RE: Intake Screening- 2206-099  
Project: 9167 SE 64<sup>th</sup> st new SFR.

Please find our responses to your intake comments:

SP-1

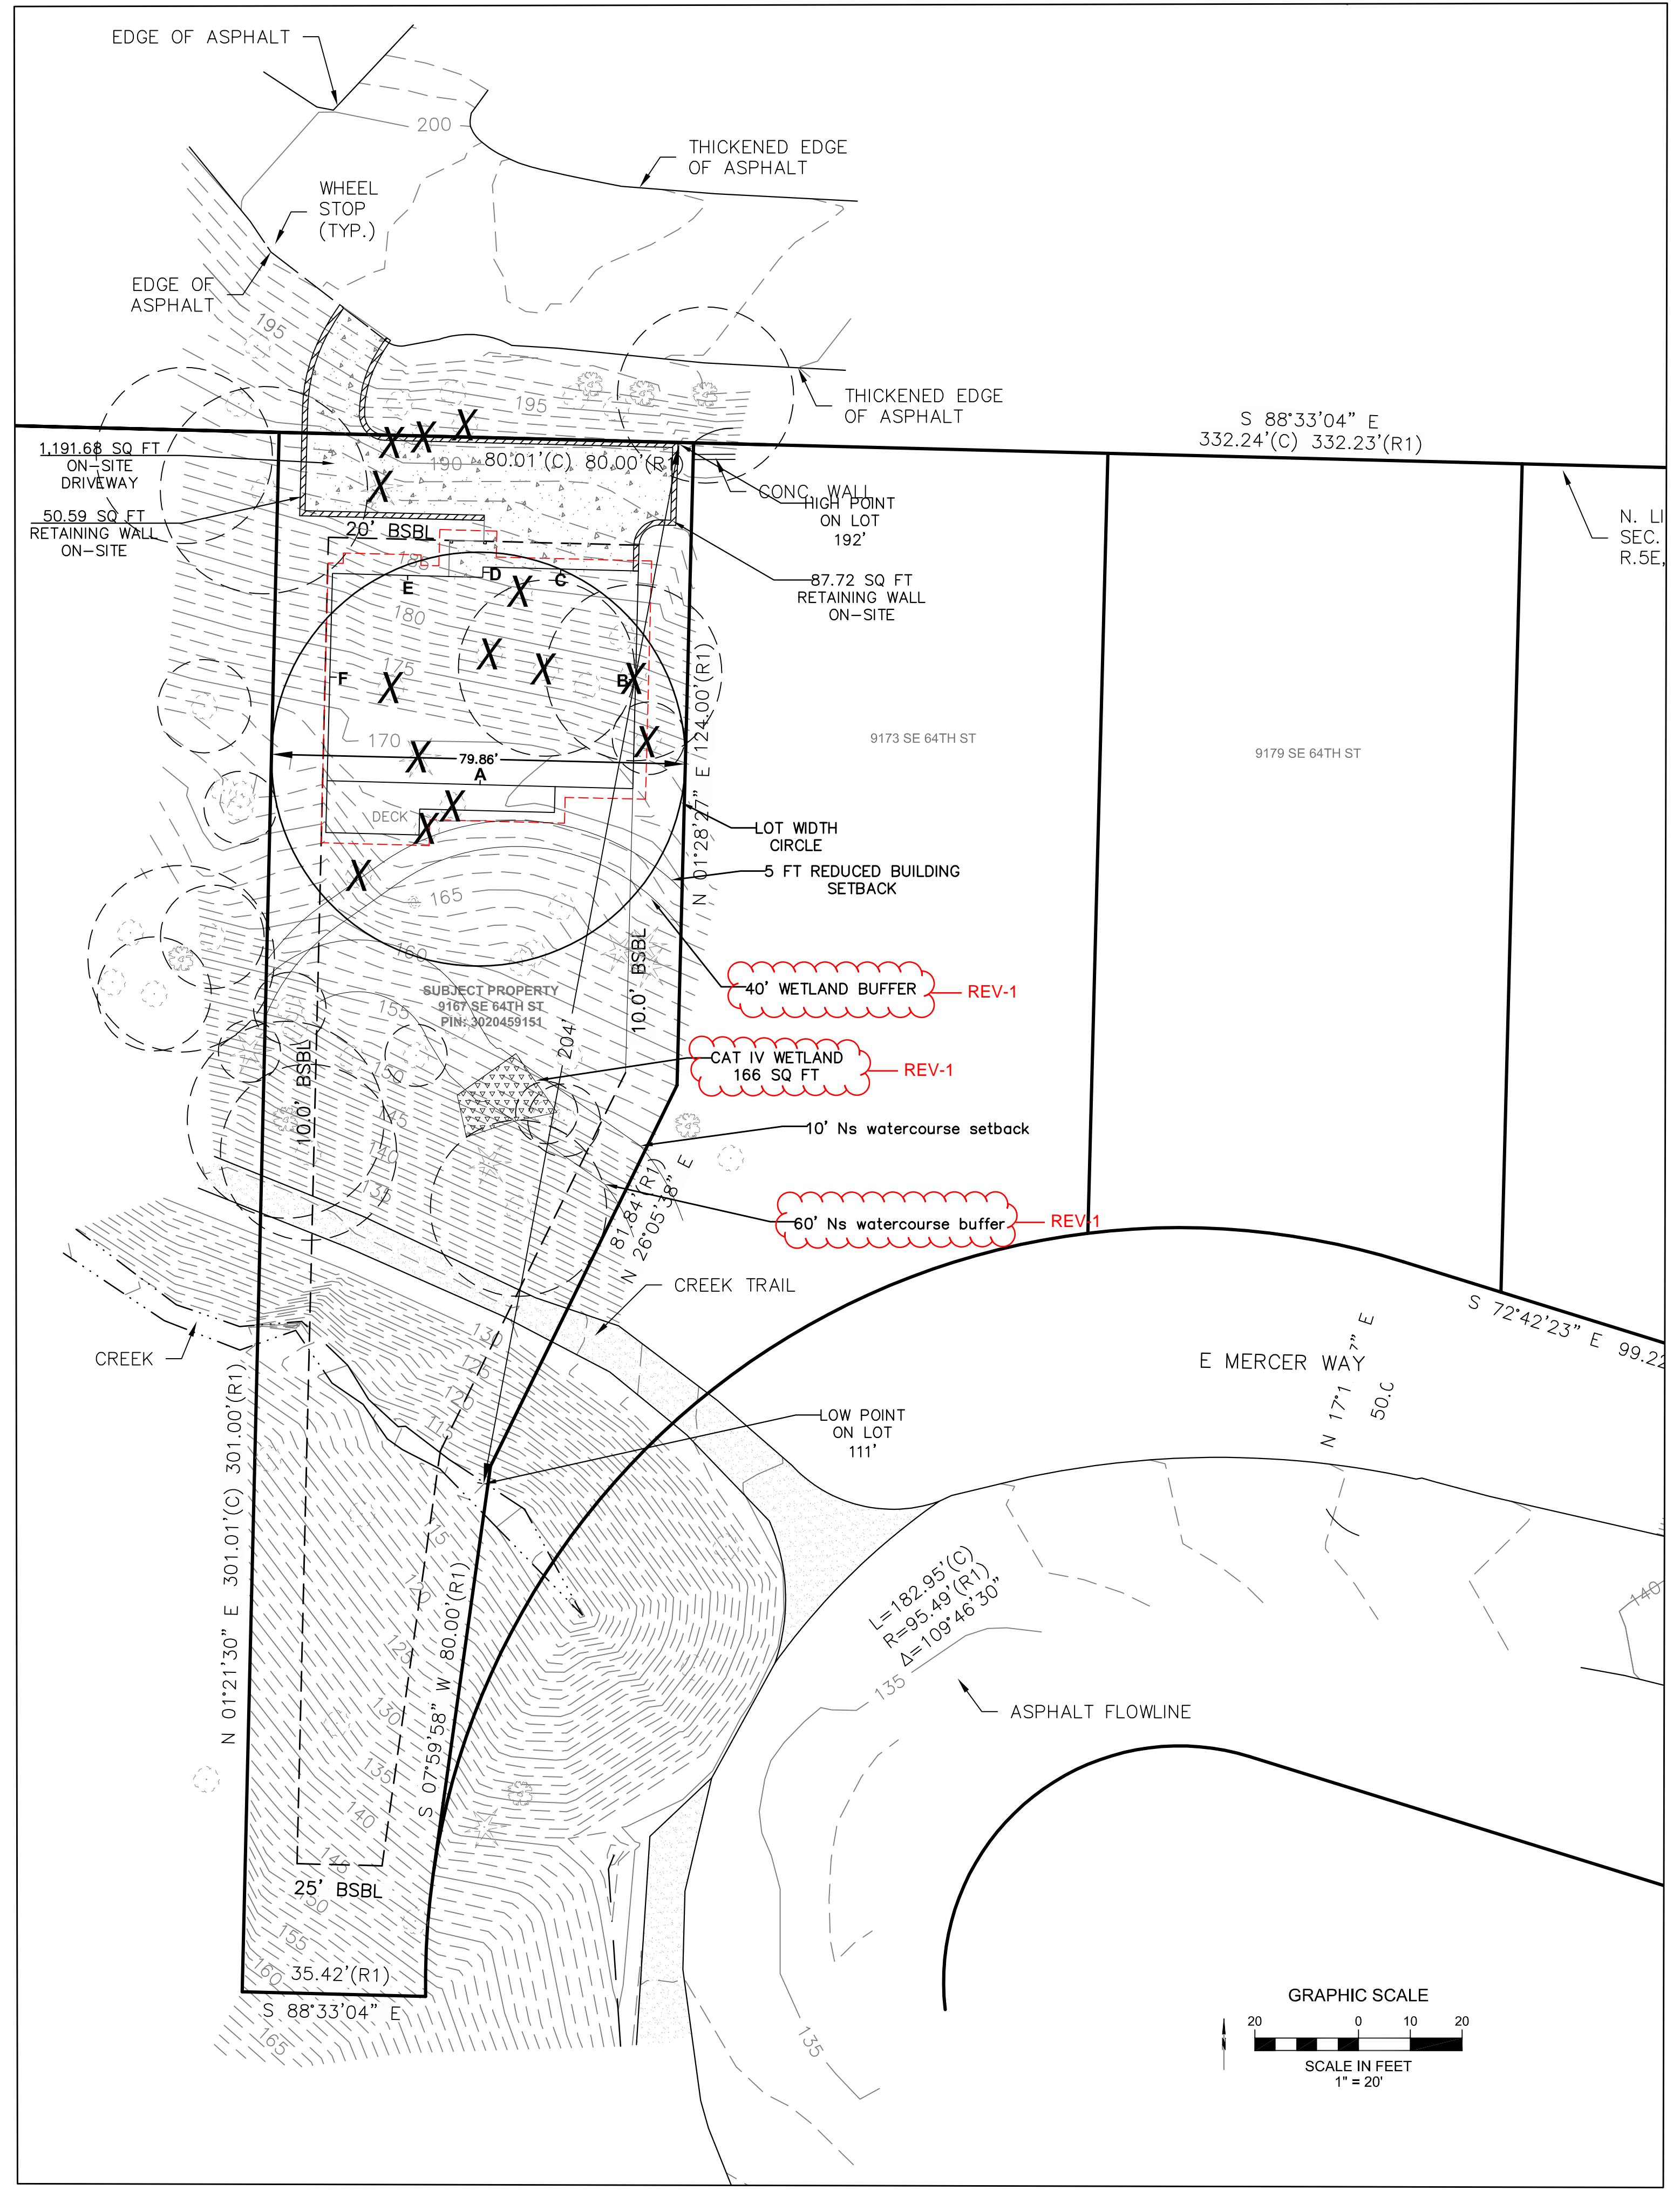
7. Andrew Leon- MICC 19.09.090(B)(1) states that any development proposal on a lot without a previously designated building pad shall establish a building pad consistent with the provisions of MICC 19.09.090(A). Under MICC 19.09.090(A)(2)(c), building pads shall not be located within critical areas and their buffers and setbacks. The City of Mercer Island GIS shows a Type Ns watercourse and its associated buffer in the eastern portion of the lot. Additionally, building pads shall be located to minimize the removal of trees and vegetation. Please revise the building pads shown on the site plan to comply with the standards of MICC 19.09.090. Please also show the watercourse and its buffer and setback on the site plan  
*We looked into the best use on this site and how we could minimize removal of trees, and the current layout on the site was determined to be the best use. The watercourse, buffer, and setback are now shown on the site plan.*

West Elevation

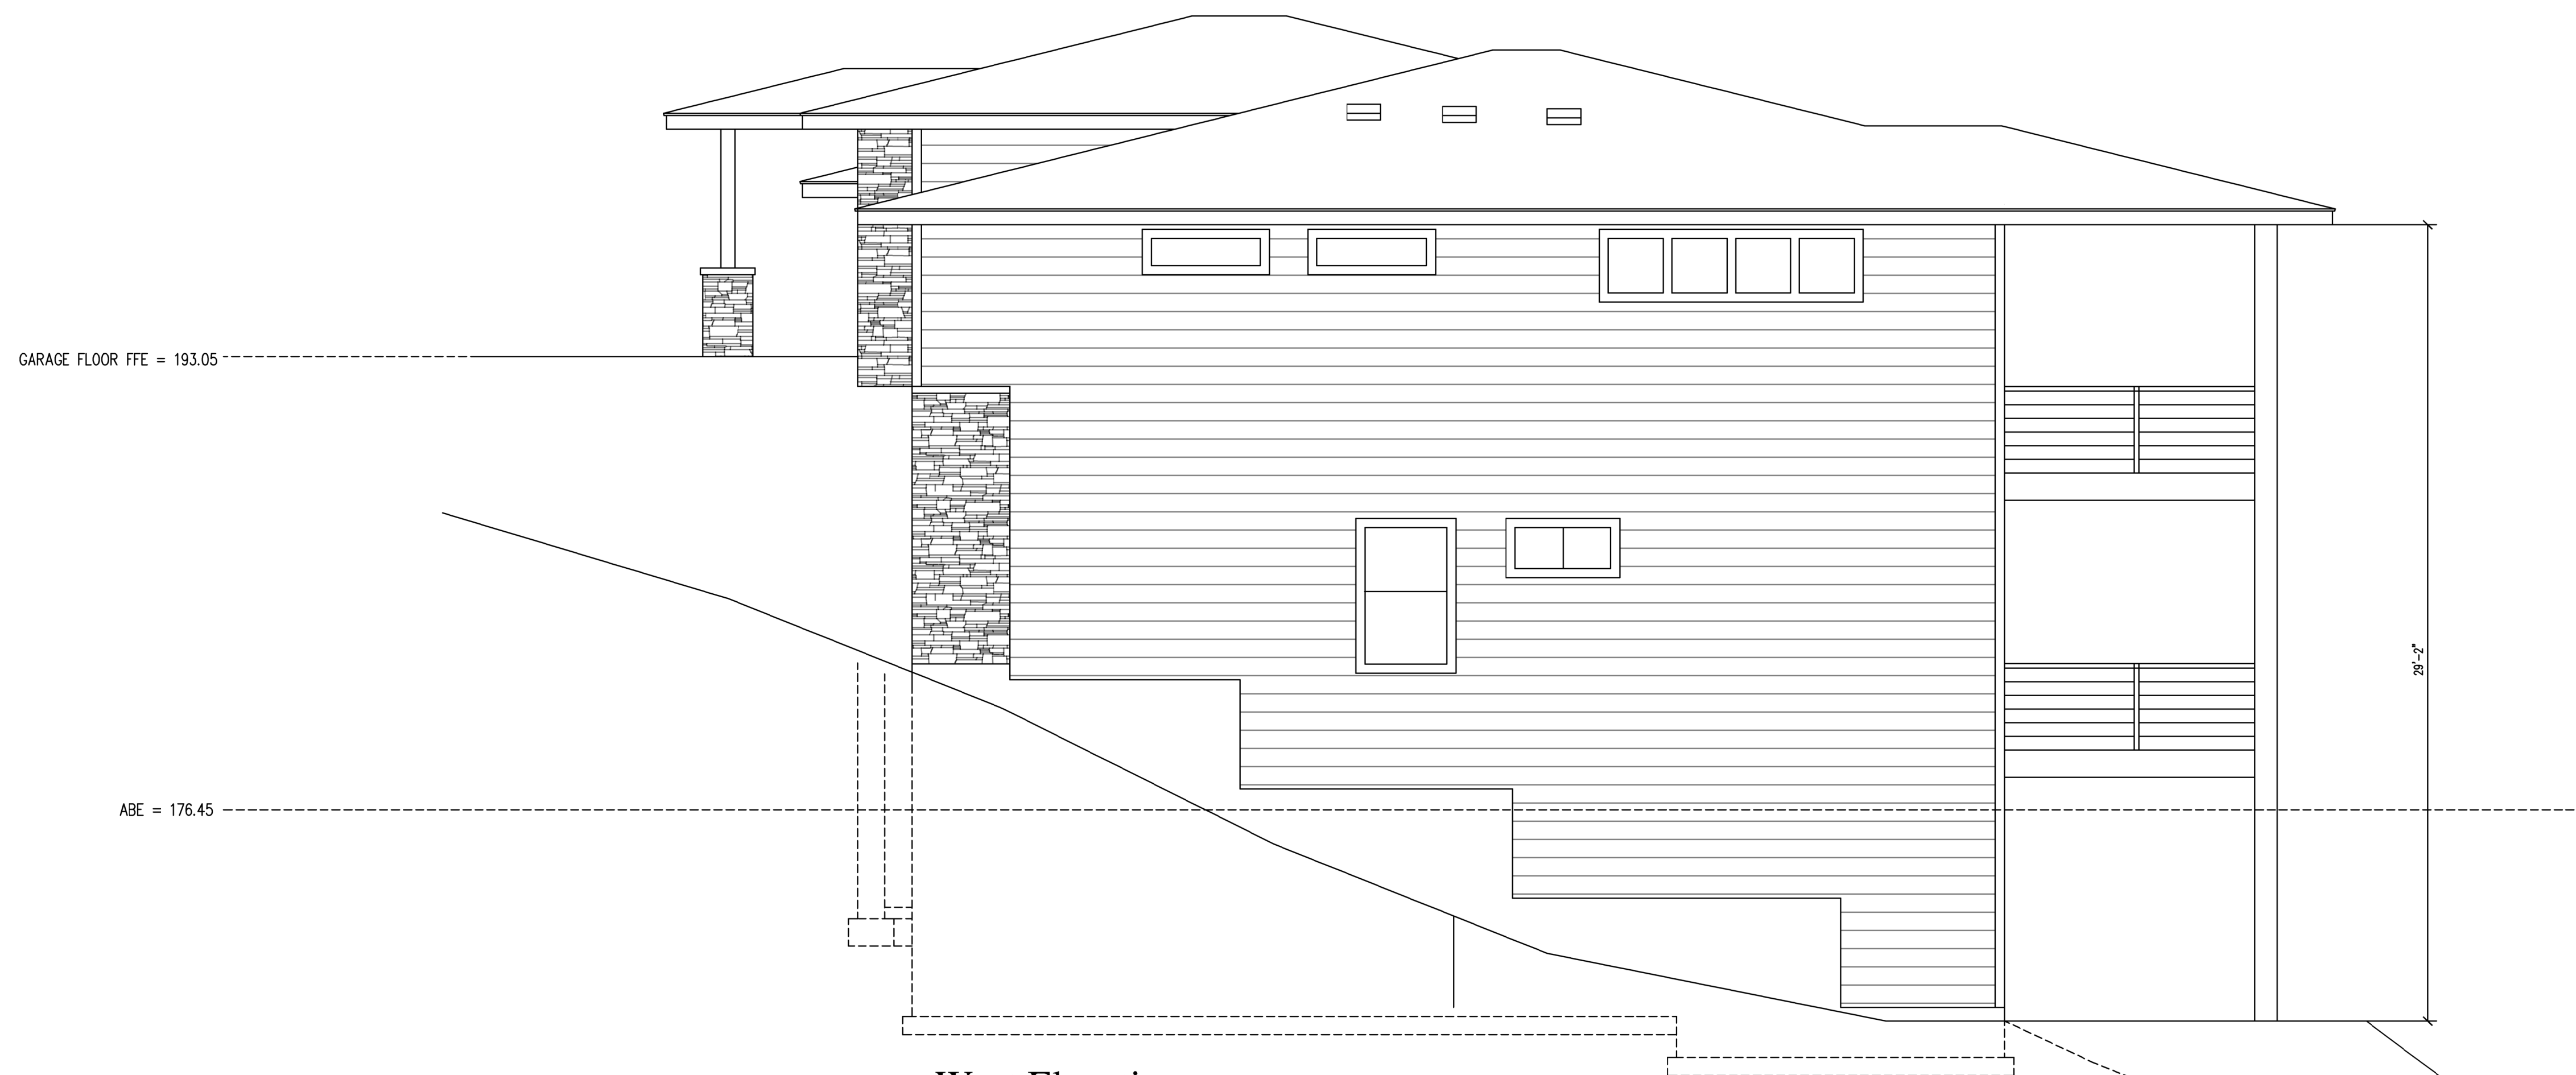
8. Andrew Leon- The plans show that the eaves of the house are proposed to penetrate into the 10-foot side-yard setback from the west property line. The elevations show that the wall facade of the west side of the house exceeds 25 feet in height. Under MICC 19.02.020(C)(1)(c)(iii)(b), a 10-foot minimum side yard setback from a property line is required when a wall facade abutting that property line exceeds 25 feet in height. MICC 19.02.020(C)(3)(a)(ii) prohibits eaves from penetrating into minimum side yard setbacks, so the eaves will need to be revised to remove the penetration.  
*We revised the eaves on the west side of the house to be 9" so they would not be in the setback any longer.*

MAIN LEVEL Floor Plan

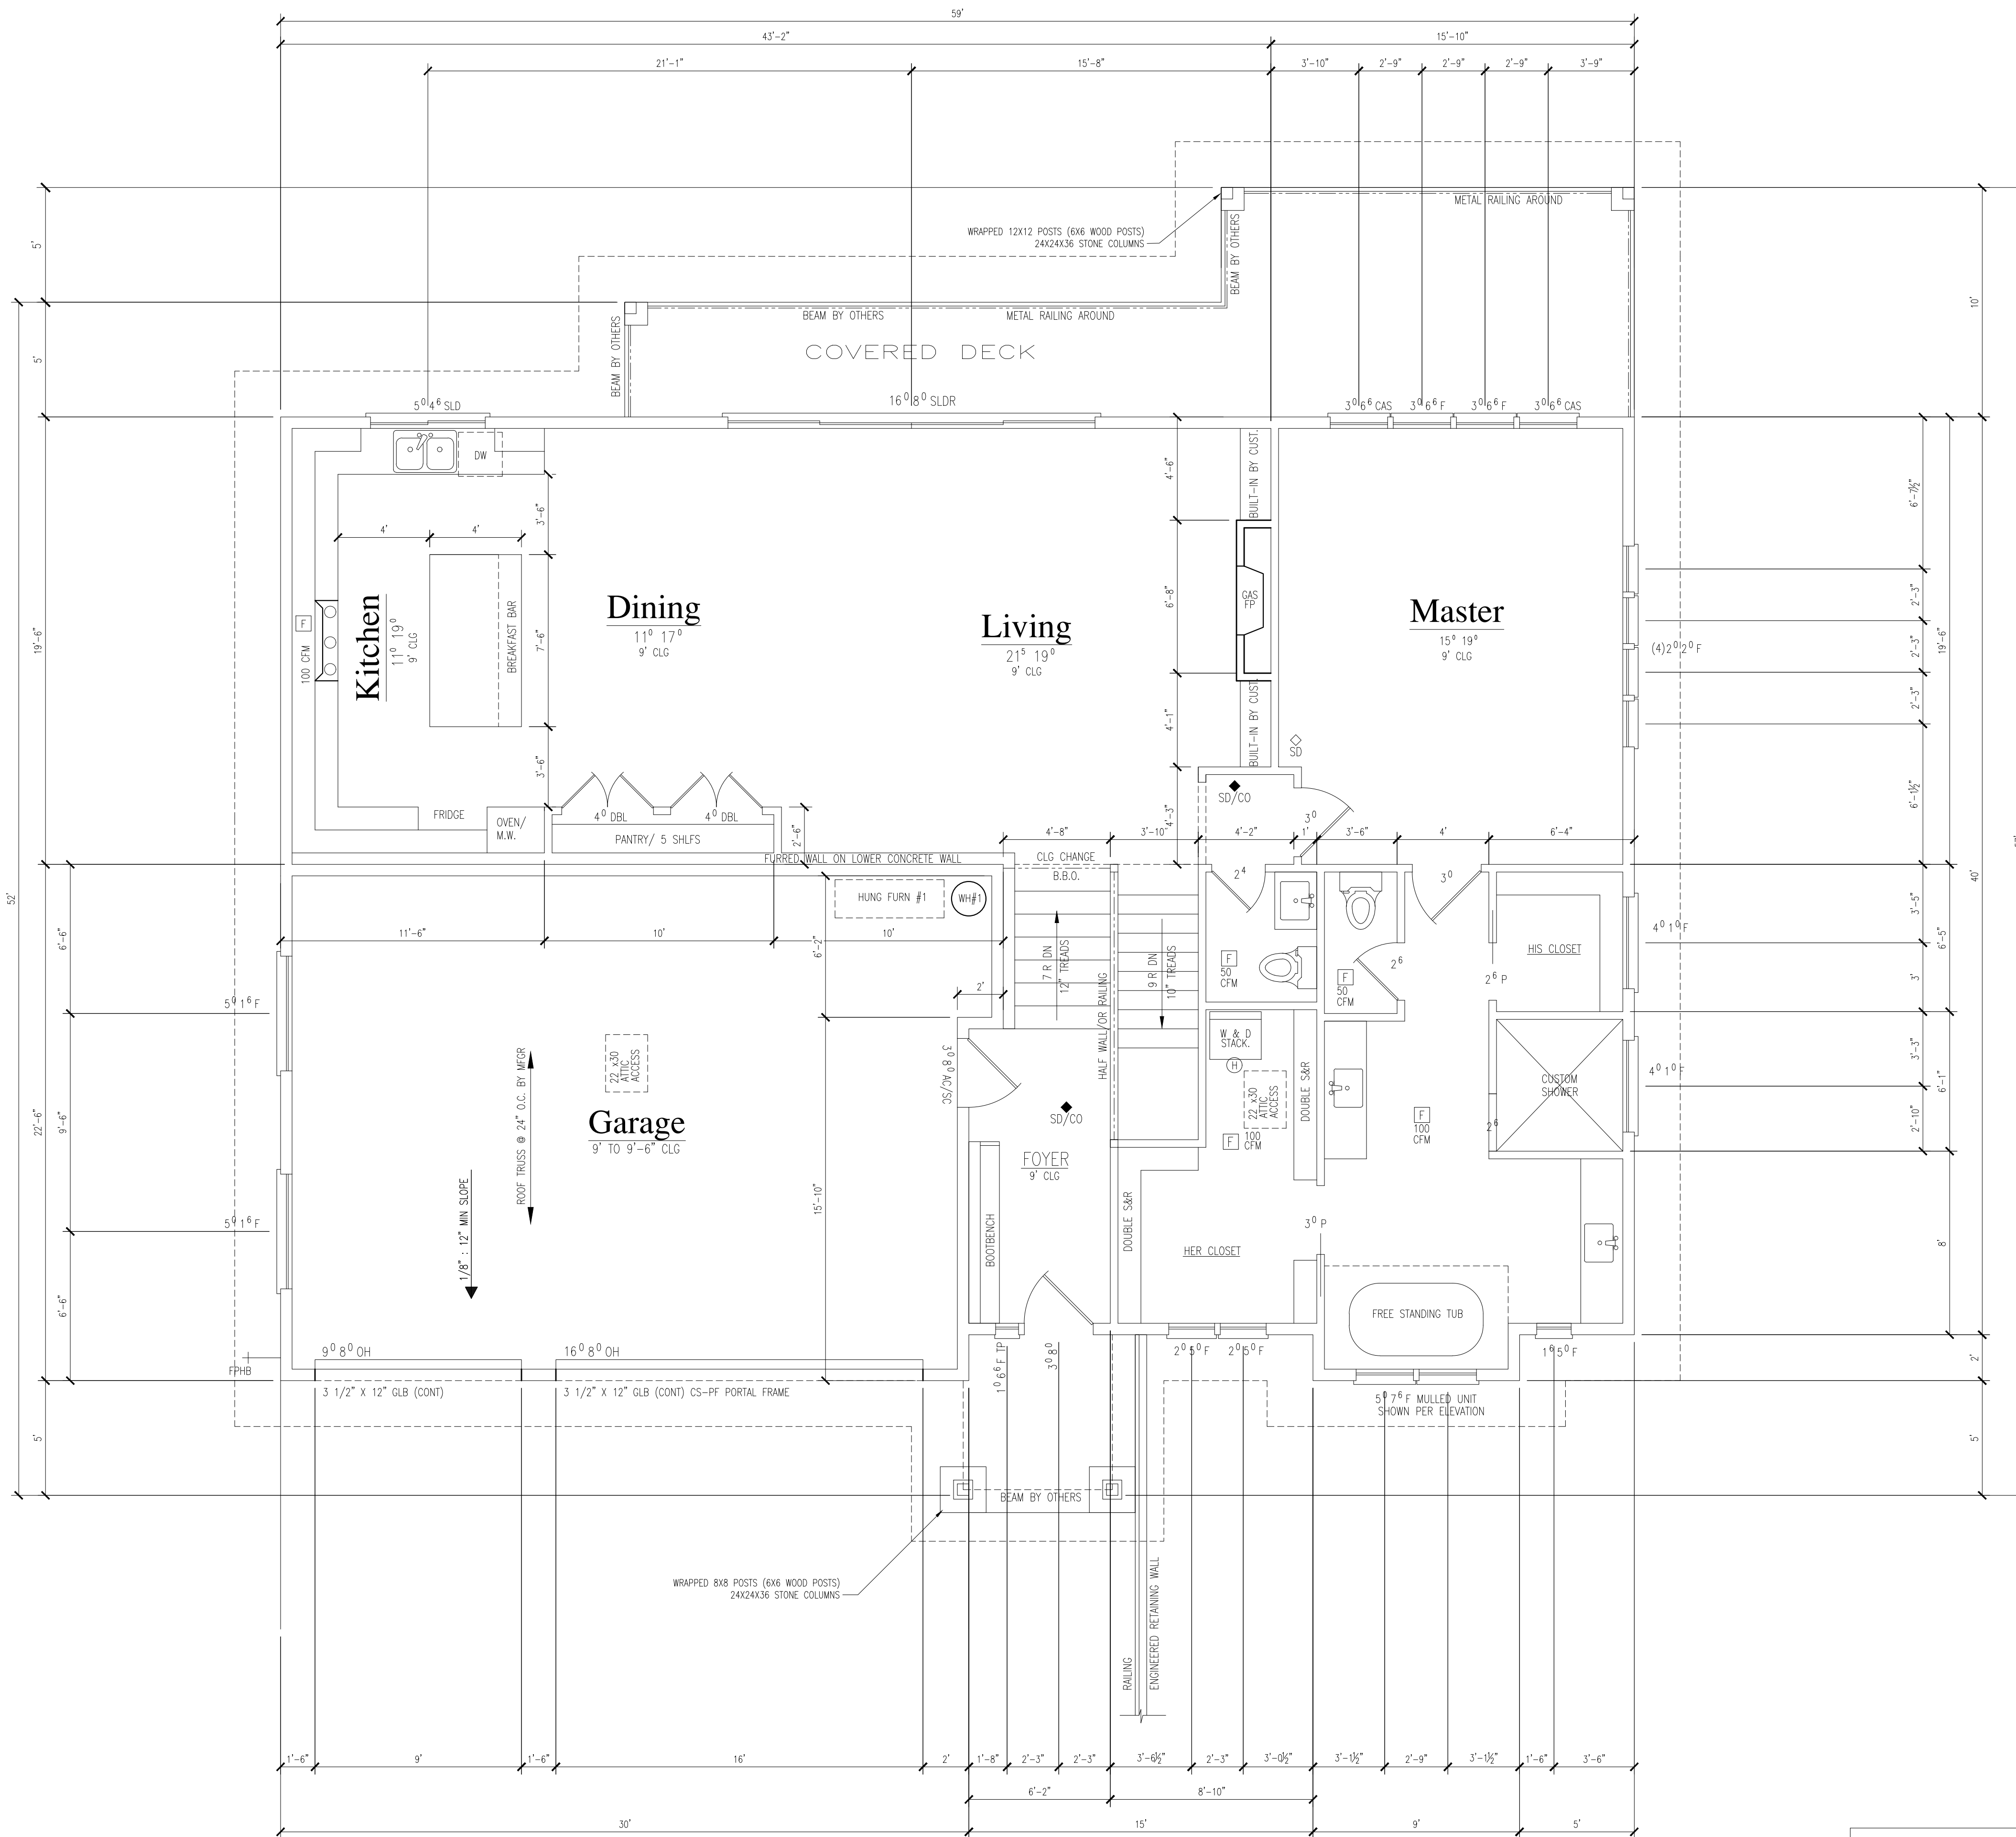
5. Andrew Leon- The floor plan shows that there is a second kitchen proposed in the lower level of the house. The lower level contains provisions for living, sleeping, cooking, and sanitation, so it could be considered an accessory dwelling unit.  
*Kitchen removed from lower floor.*
